2280.08-DRAWING REVISION SCHEDULE

EXISTING SHADOW DIAGRAM - 21 DEC AT 12PM

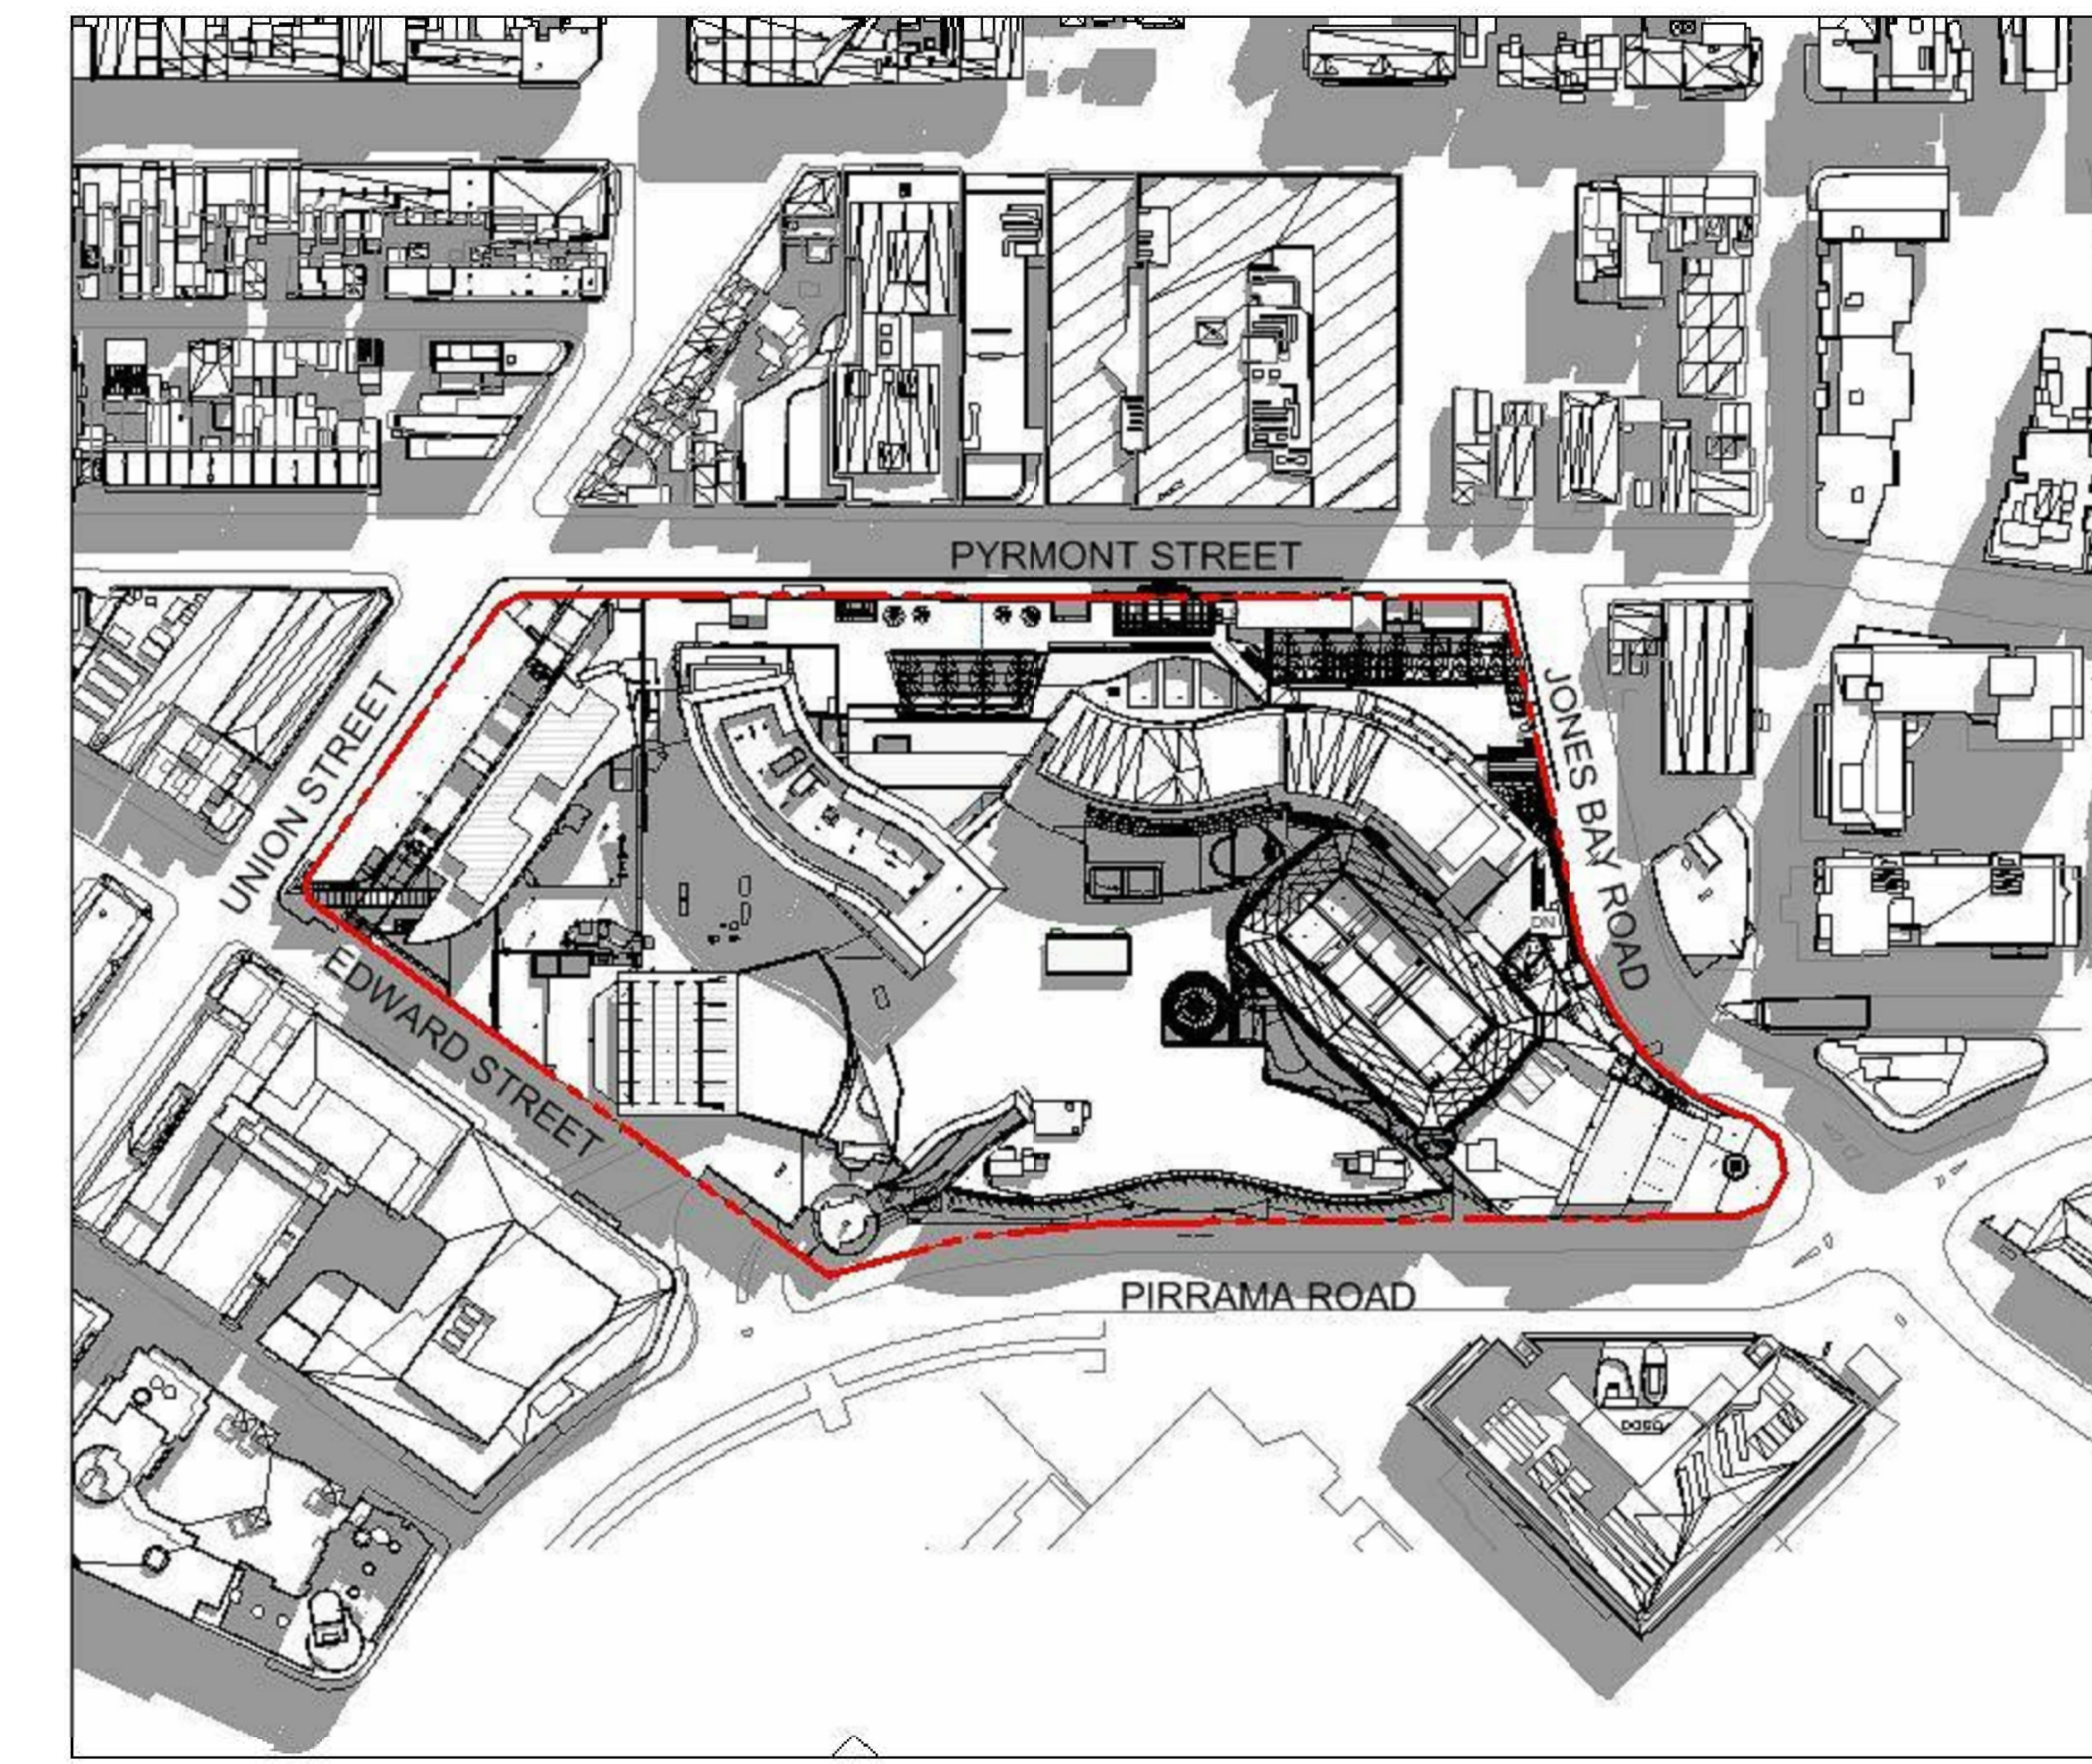
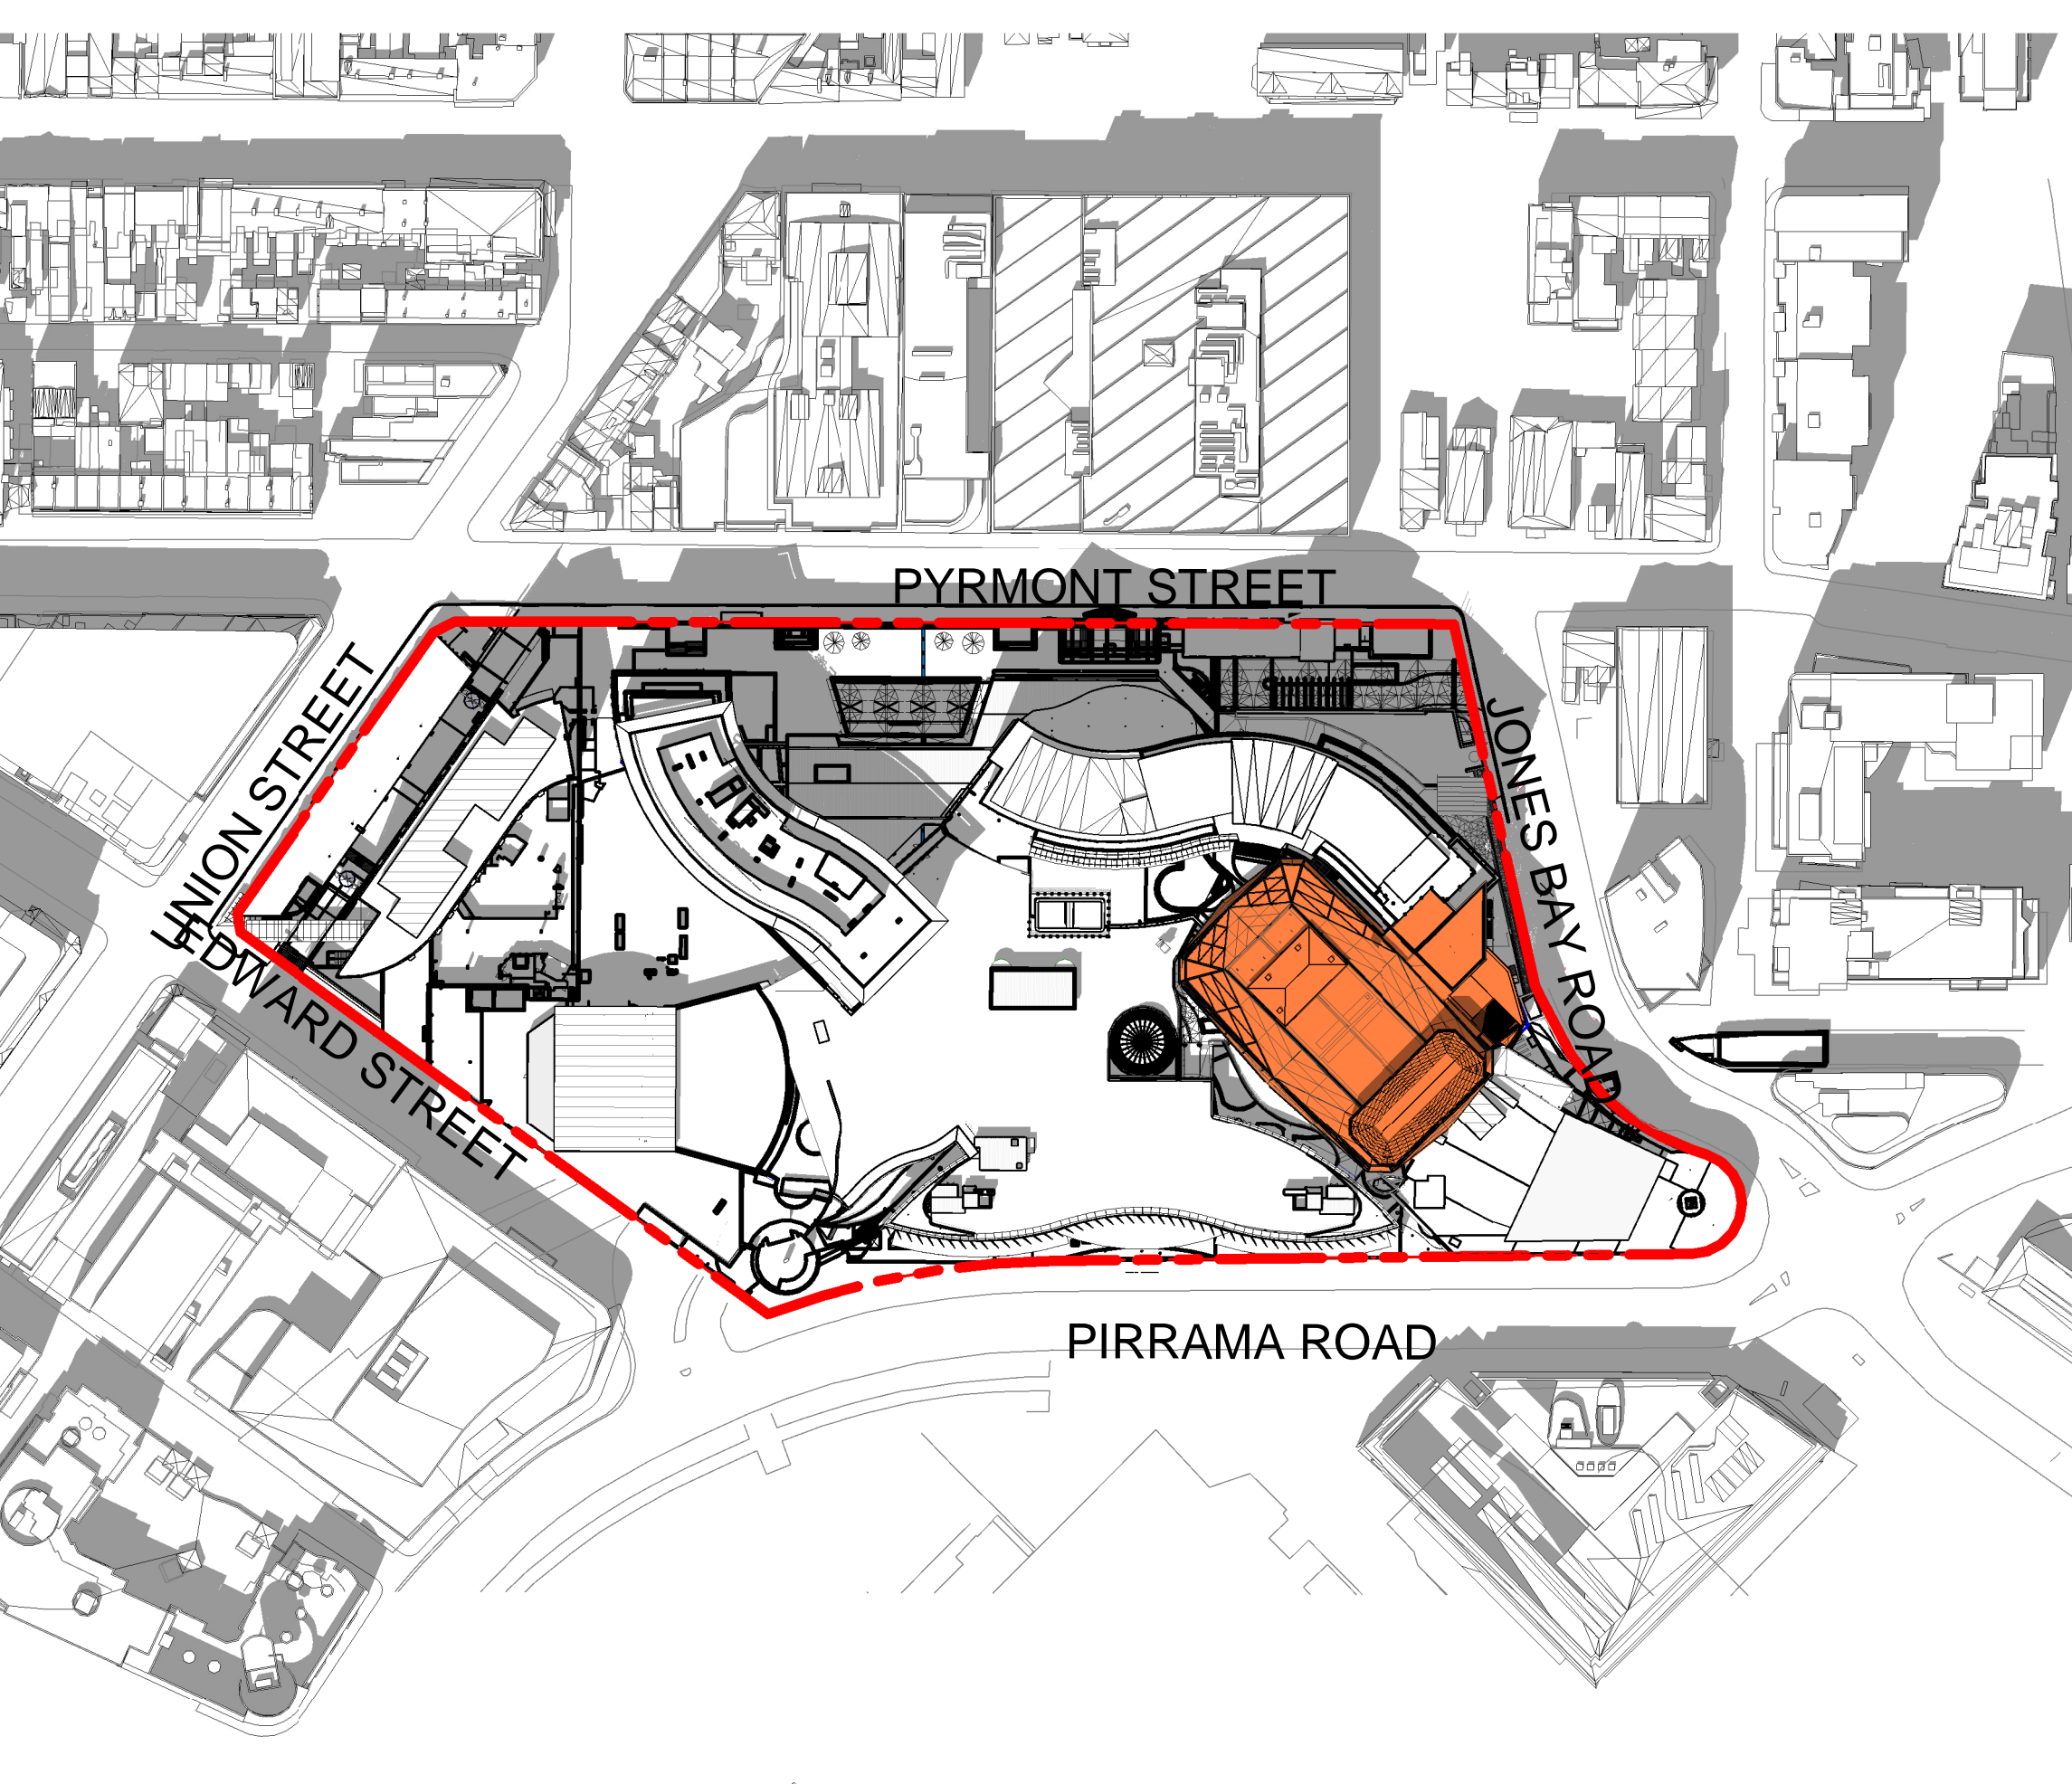
1. Footprint of fly tower reduced to suit comments from DPE and City of Sydney.
2. 4 level extension over existing dressing rooms reduced to 3 levels over existing dressing rooms. Aluminium clad screen extending from 4 level extension and on front of existing plant room omitted.
3. Double height plant room extension omitted from scope.
